SOUTH ACADEMY BUSINESS CENTER

4425 HWY 85-87
EL PASO COUNTY, COLORADO
SITE DEVELOPEMENT PLAN

FILE NO.
PCD 17-004

Markup Summary

SOUTH ACADEMY BUSINESS CENTER

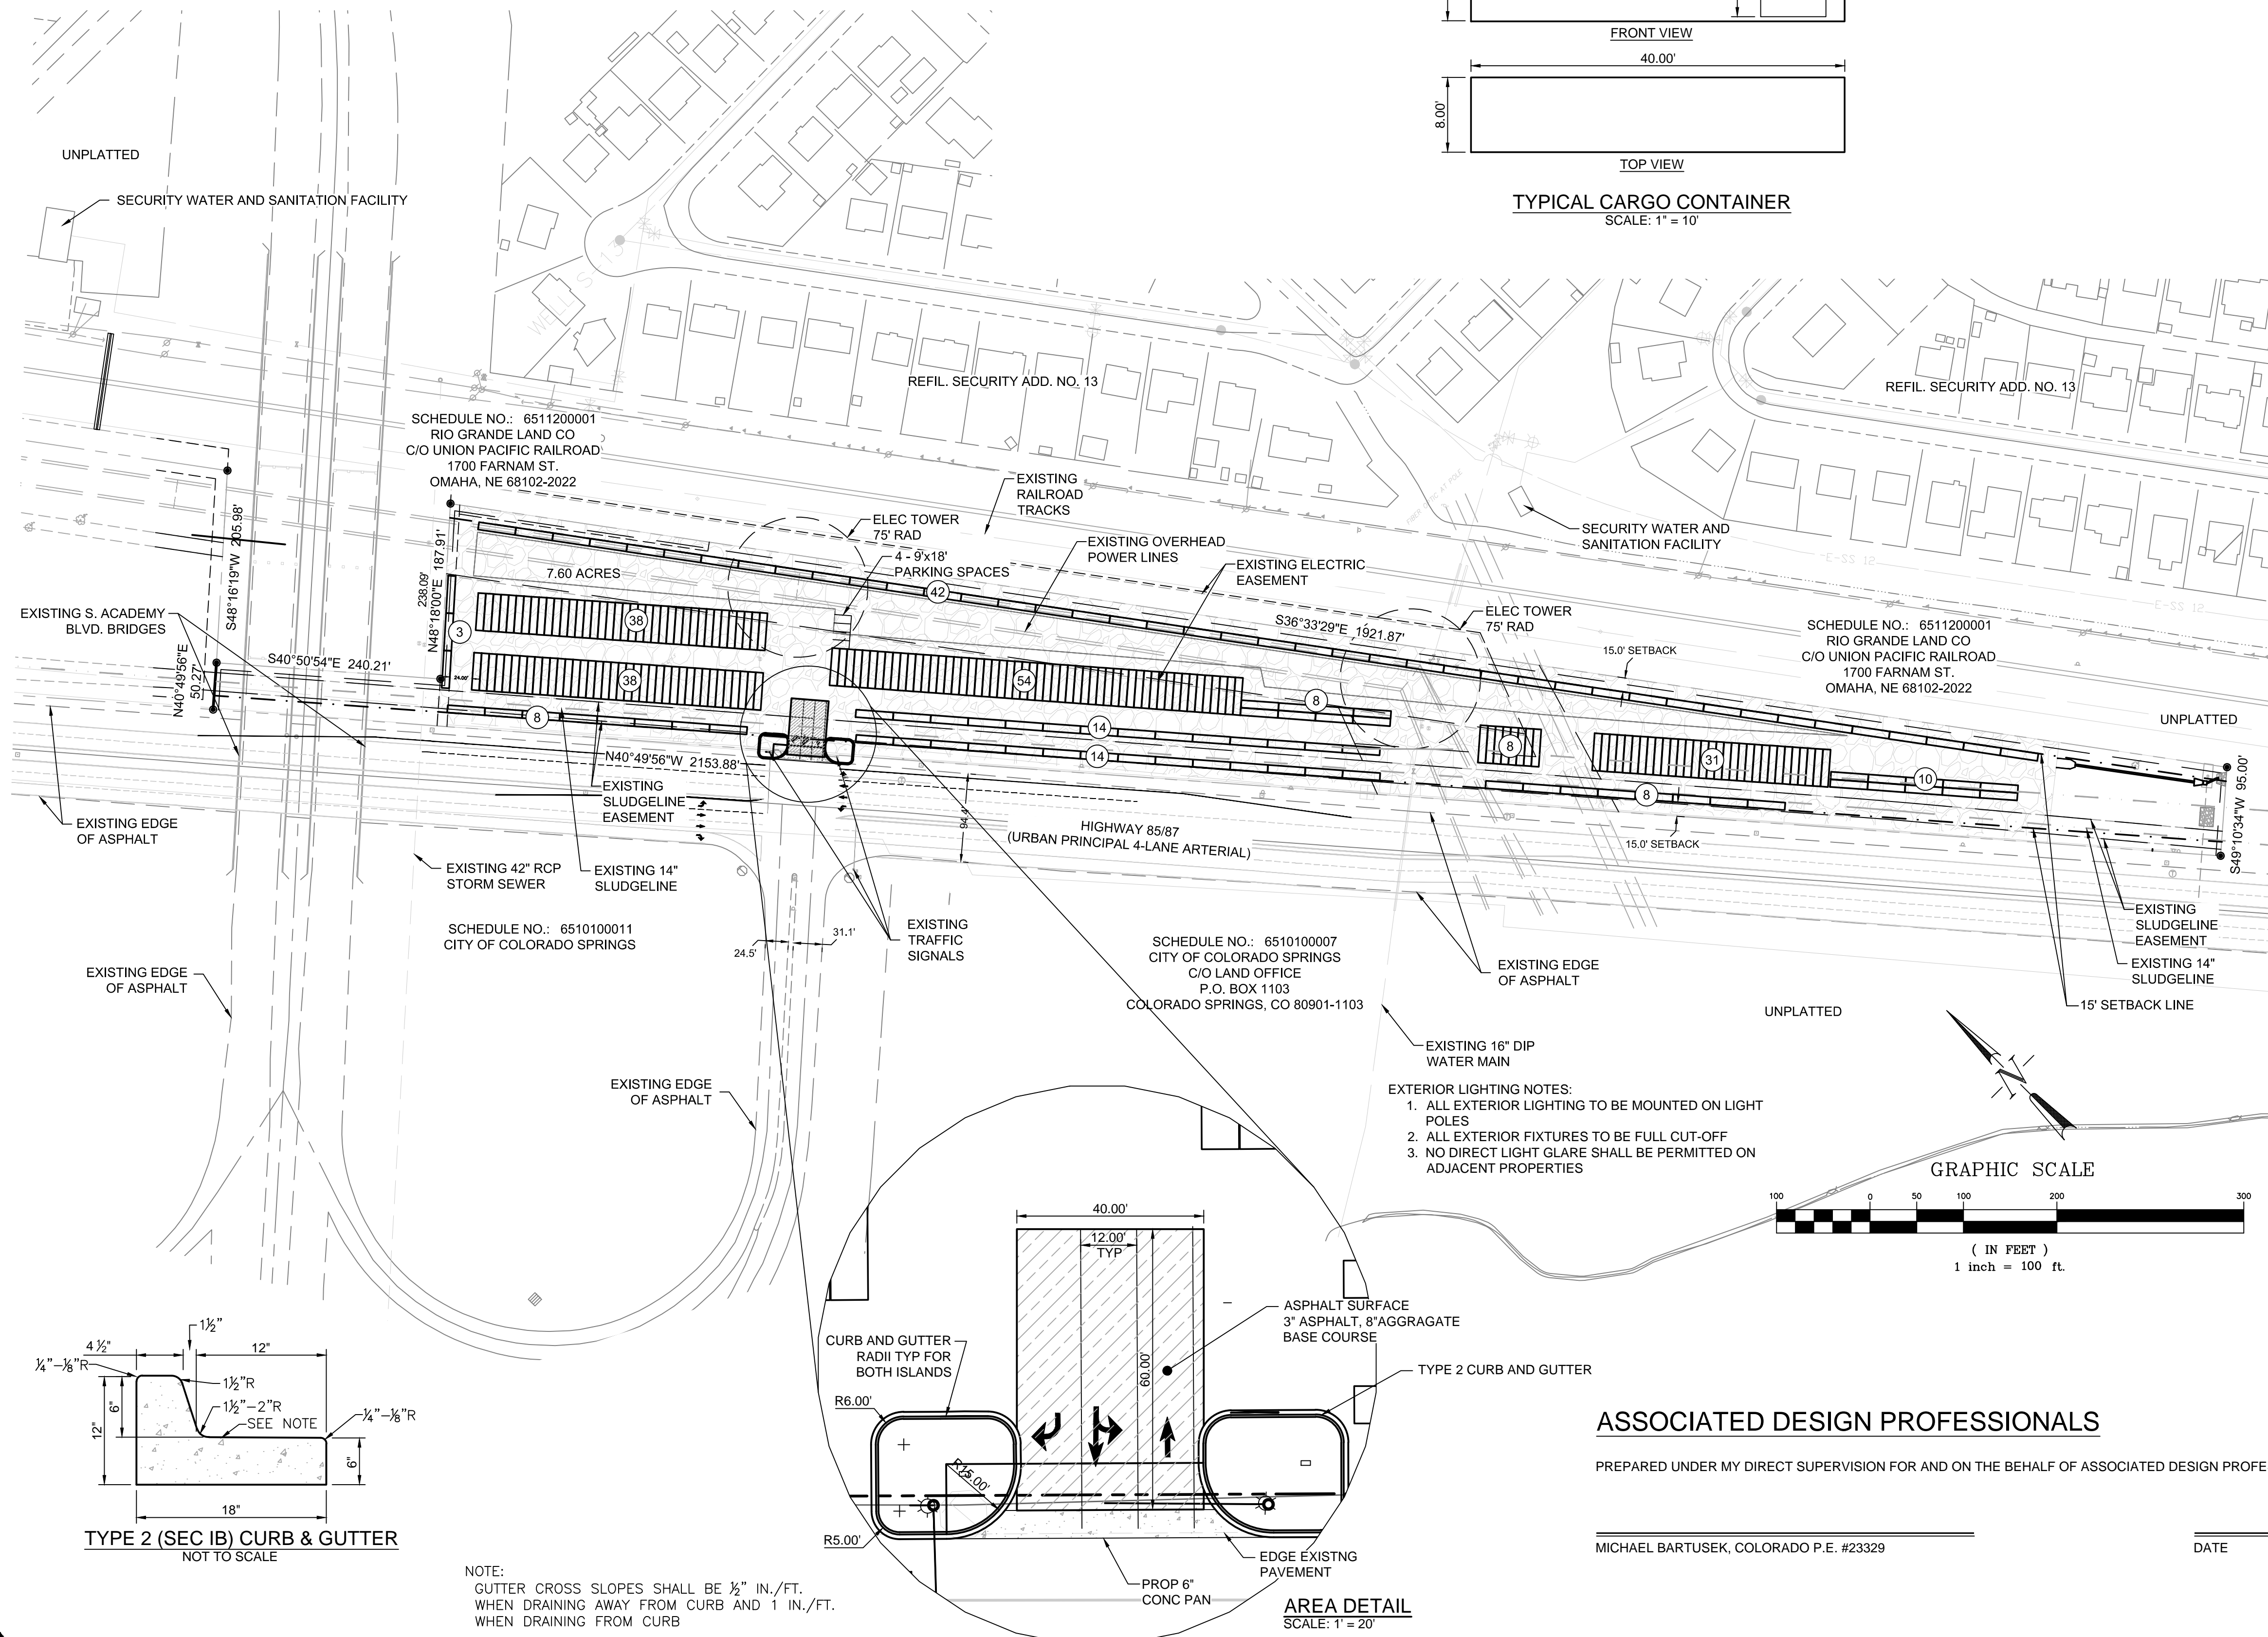
Parking?
Mini Warehouse requires 1 space per 100 units plus 1 space per employee.

Setback variances of more than 20% of the required setback (15 feet) would require a Board of Adjustment Hearing, not a deviation. The Board of Adjustment application is an additional process involving a public hearing.

These measurements should be the same. It looks like the 8' measurement is below the top of the structure, it should be corrected.
